**Recommendation Report for Listed Building Consent for Alterations, Extension or Demolition of a
Listed Building**

REF NO: Y/68/22/L

LOCATION: Berri Court
Main Road
Yapton
BN18 0ED

PROPOSAL: Listed building consent for the erection of detached workshop, gym/hobby and greenhouse.

ALITEX [®]		TITLE NATIONAL TRUST GREENHOUSES THE WIMPOLE WITH SPECIAL BENCH. (NT-WIMP-ST-R-D-C-X-RAL 9005)		
DRAWN LC	DATE 23/02/22	SCALE 1:50 @ A3	DWG NO. NT/HARD30539_GP. Sheet 1 of 2	REV -
CHECKED NR 24/2/22	No. Berricourt.		30539

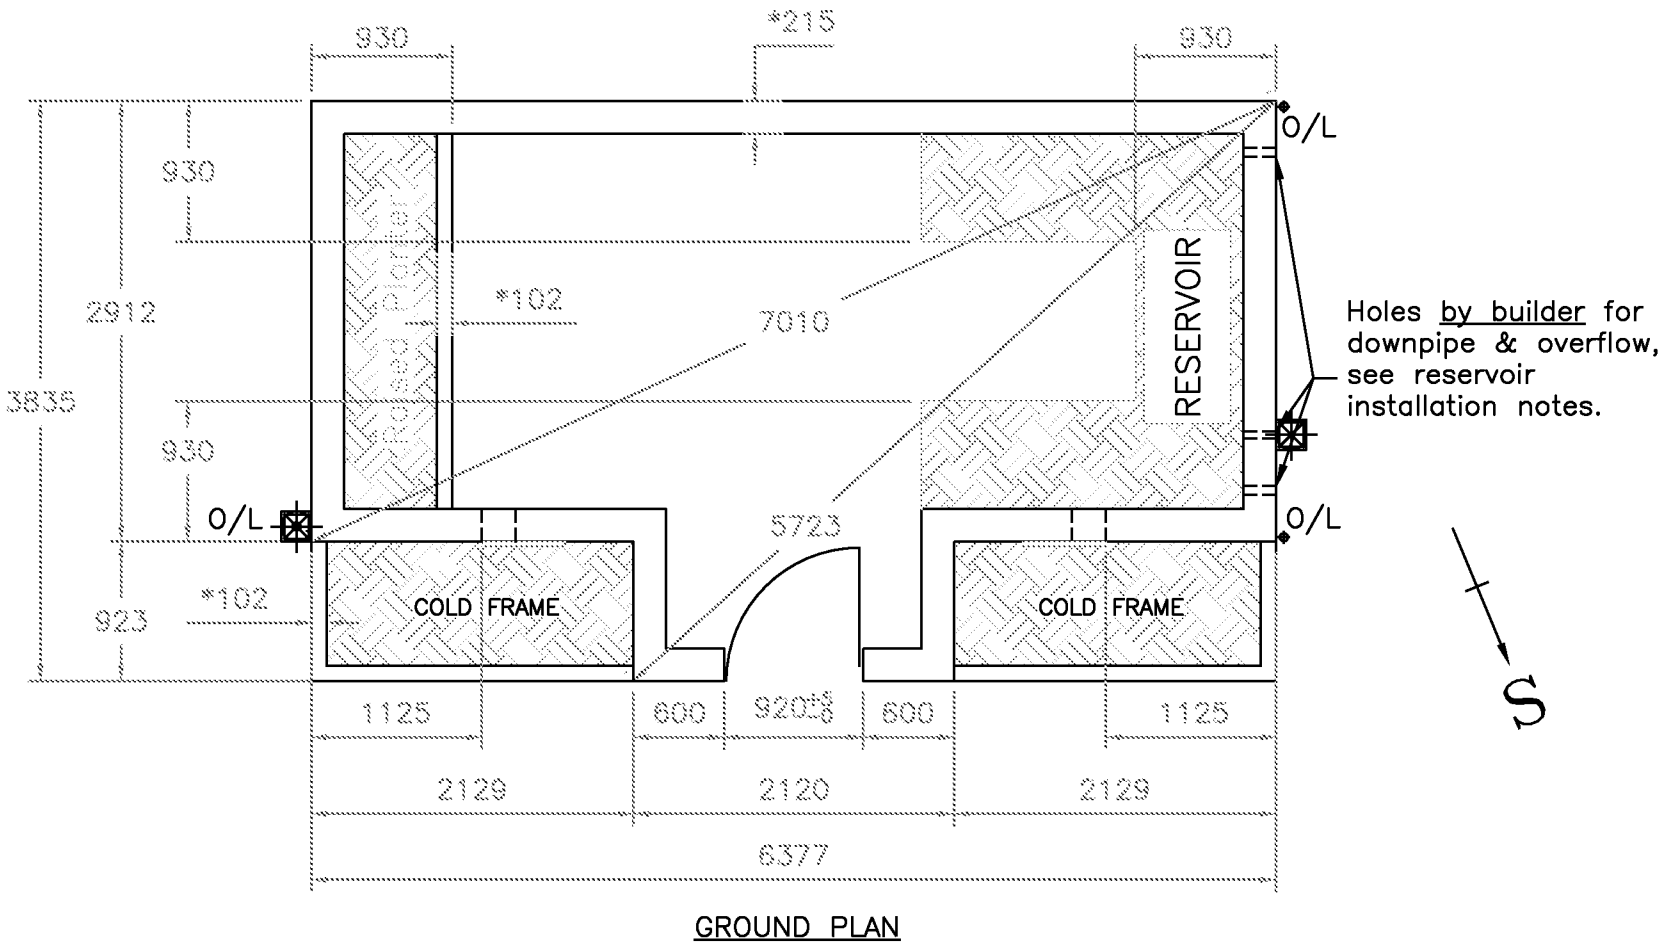
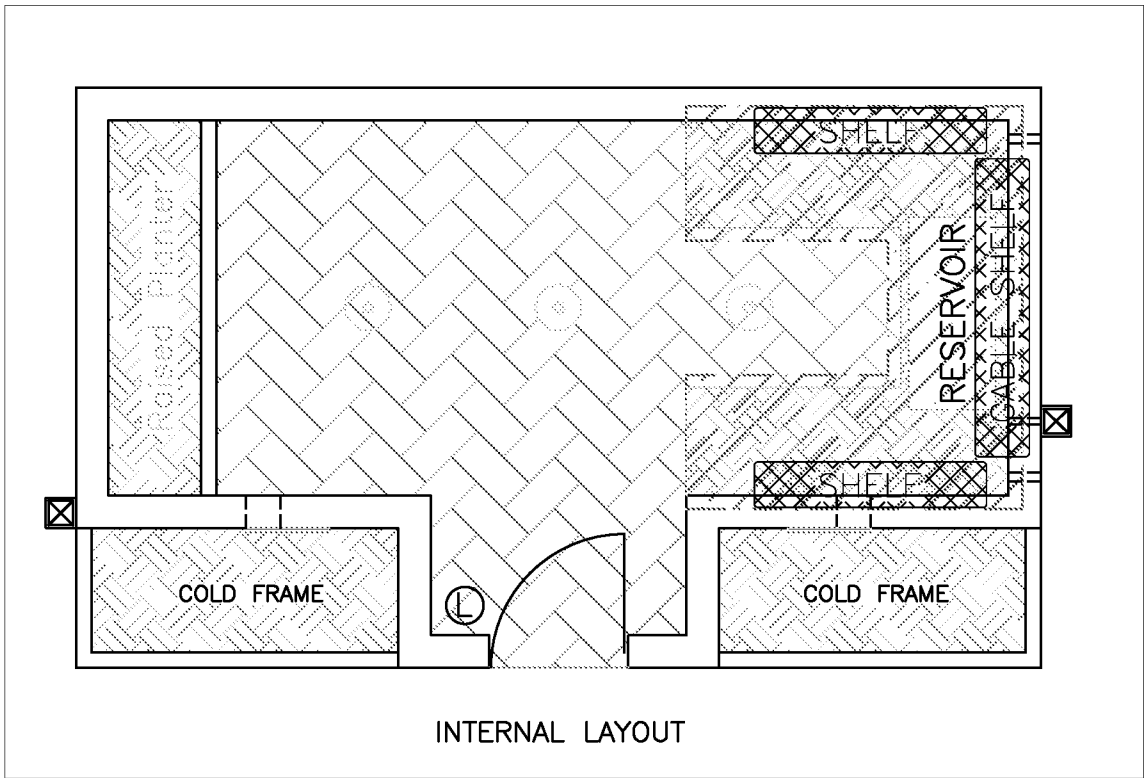
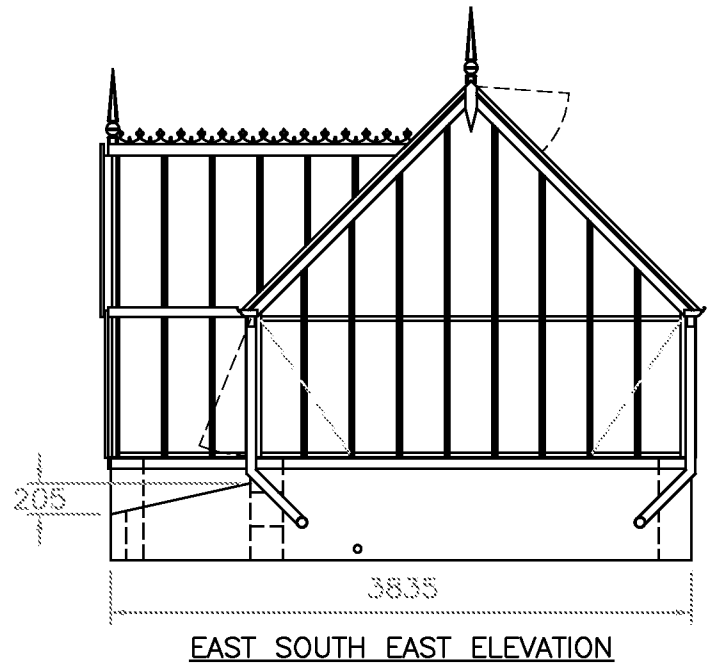
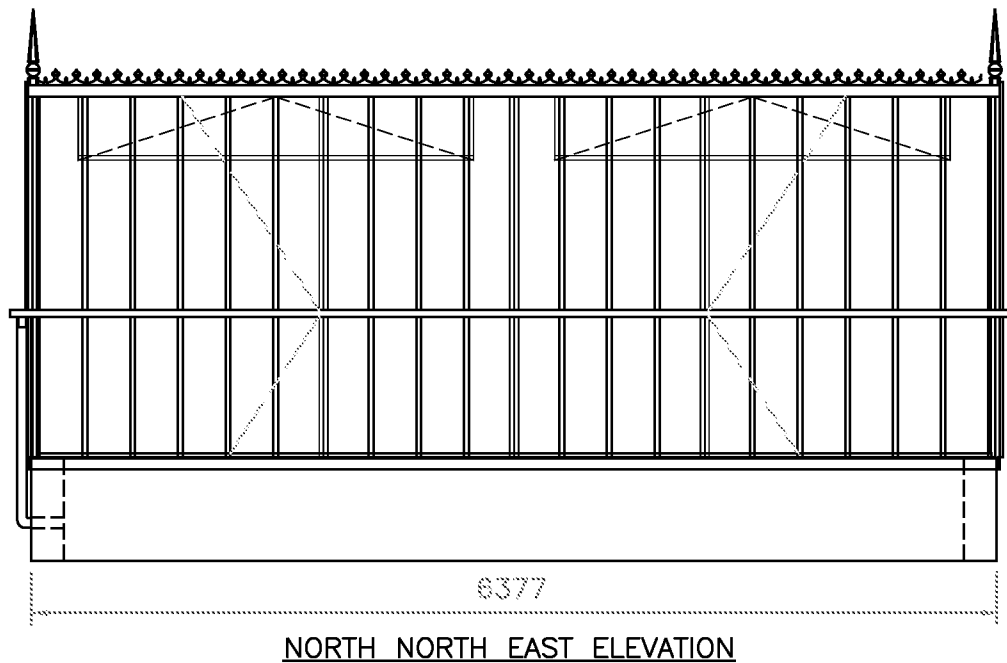
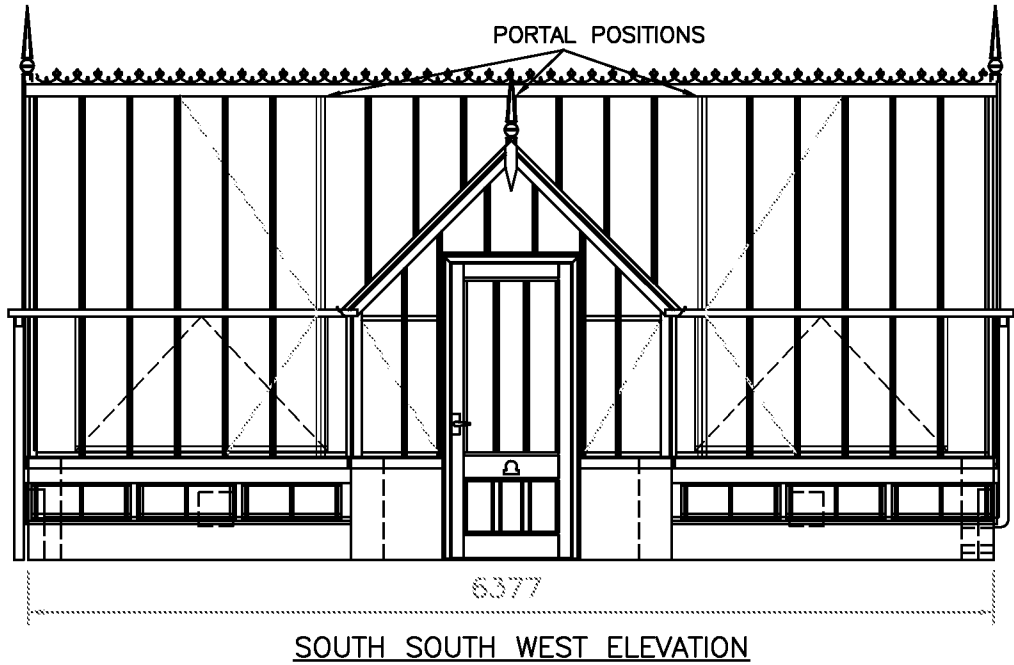
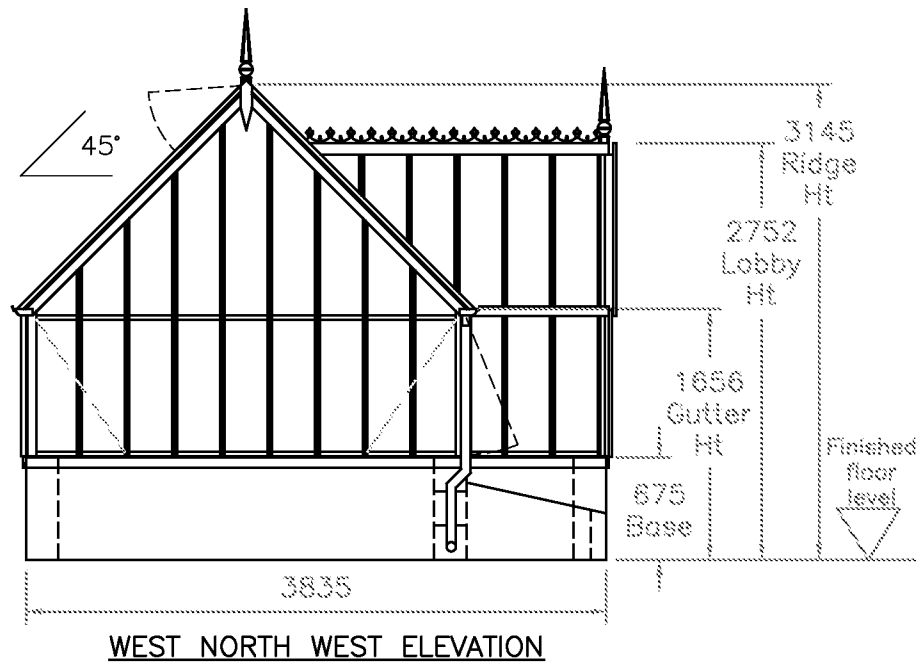
- The greenhouse is acceptable in planning terms reflecting both the listed building's heritage and that of the conservation.
- Issues regarding the compatibility in terms of design or function of the proposed adjoining workshop/hobby room.
- Request for an elevation drawing showing both the workshop and greenhouse in context against the listed building and its setting.
- Asks that this application be deferred until such a drawing is issued.
- Objects to the application in its current form and would seek that the workshop/hobby room is removed in its entirety from any proposal that may be considered currently or in the future.

The gym/hobby room structure would be located in a separate garden space to the rear of the house and would form part of a small courtyard type space, with existing attractive planting/landscaping. The design of the workshop and gym/hobby structures is contemporary and not pastiche, which in the context of their size/location is acceptable. The dark colours, along with the sedum roofs would help them to have a neutral impact upon the listed building. The success of such a scheme will depend upon the details of the design and fenestration. It is suggested that further details of the windows and doors should be provided so as to ensure that they are of an acceptable appearance. The glass house is of a more traditional design, and like the other two structures would have a neutral impact.

Title
SITE PLANS

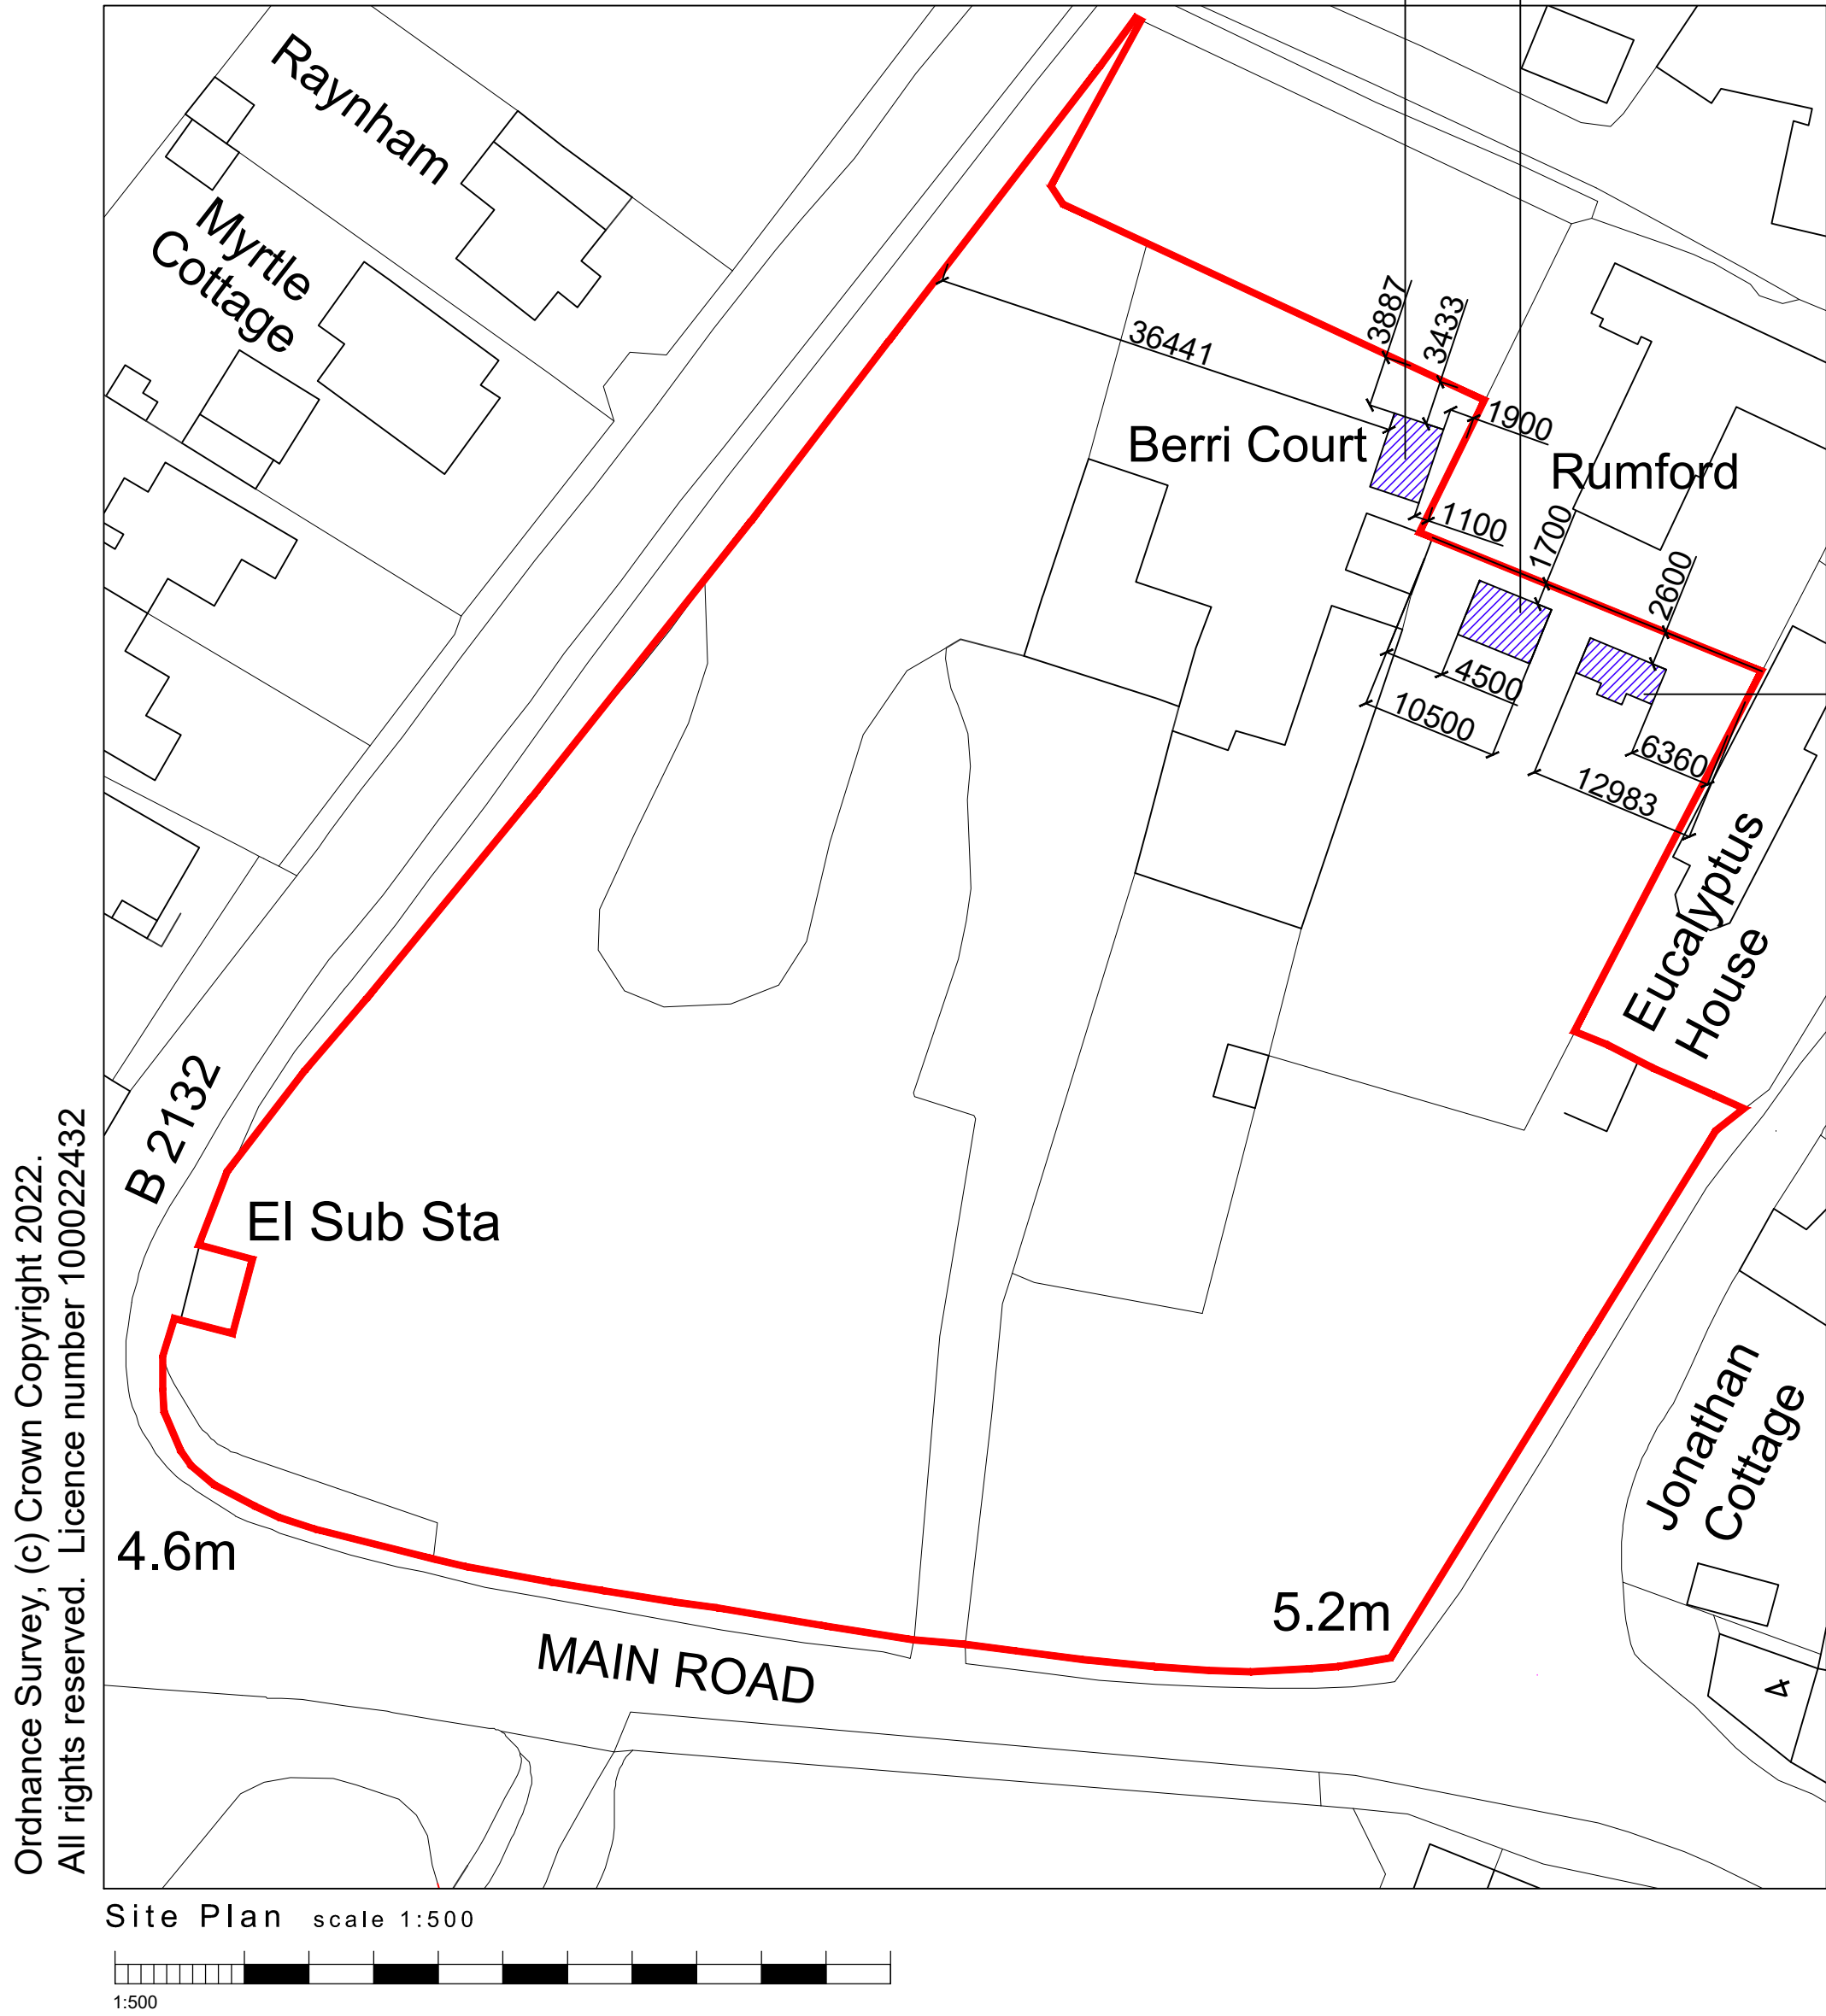
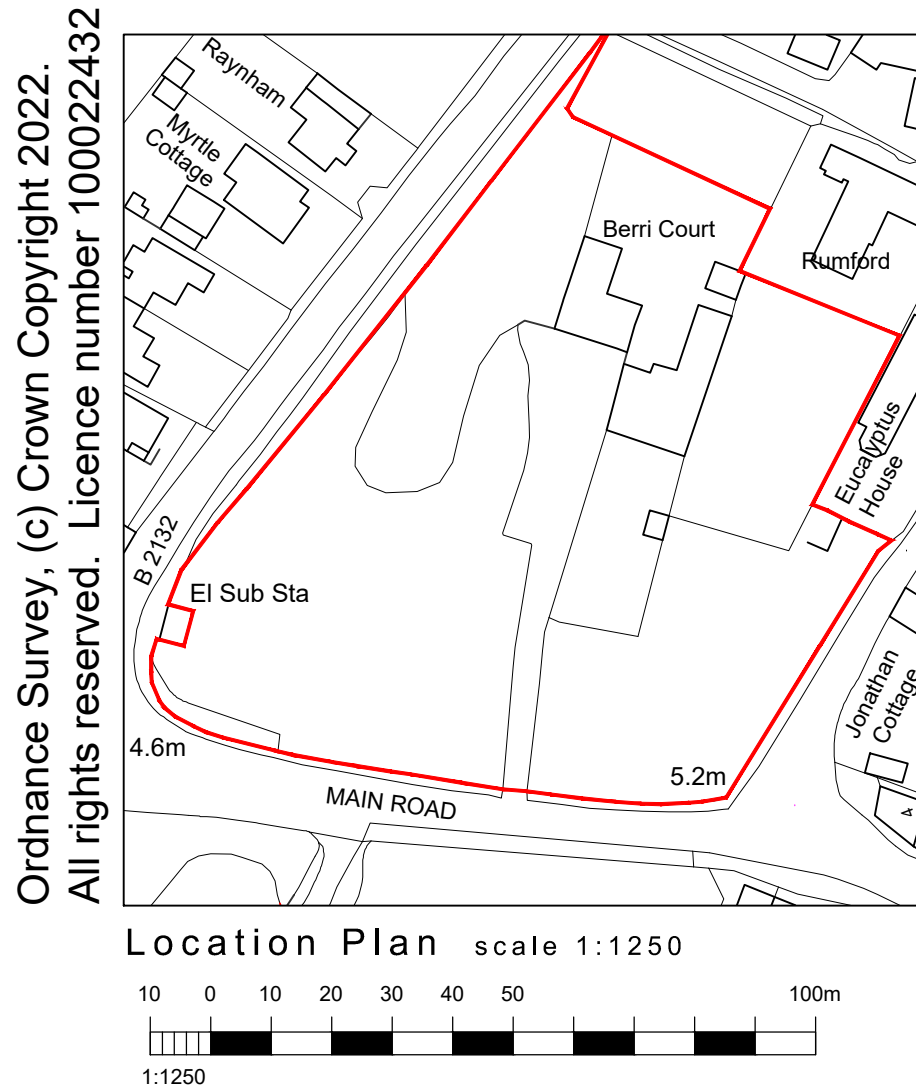
- Neither application appears to have included a Tree Report. The Site Plans do not show the location of trees.
- Heritage Statement - Design and Access Statement remains unchanged and lacks important details including the historical evolution of Berri Court, and Rumford and Eucalyptus House; the effects of the proposed scheme; and consideration of alternative locations.
- No sectional plan showing the existing house with the proposed outbuildings, together with neighbouring properties.
- The proposed structures could be moved to a minimum of 2.6m away from the boundary wall.
- While the proposed design of the greenhouse could be regarded as sympathetic, the workshop and gym/hobby room are not considered in keeping.
- Serious and intrusive issue of noise from the workshop and gym/hobby room.
- Possible pollution from the workshop.

The greenhouse and the workshop would be to the side of the house in a walled garden; the northern, eastern and southern boundaries of this space are walling, whilst the western one is predominantly the listed building itself. The structures would back onto an existing wall and the gym and workshop would form a small group with an existing building. The presence of existing screening/walling means that the location of the structures would not be clearly seen from the main roads in the conservation area, and it is considered that the plans are slightly misleading in this respect.
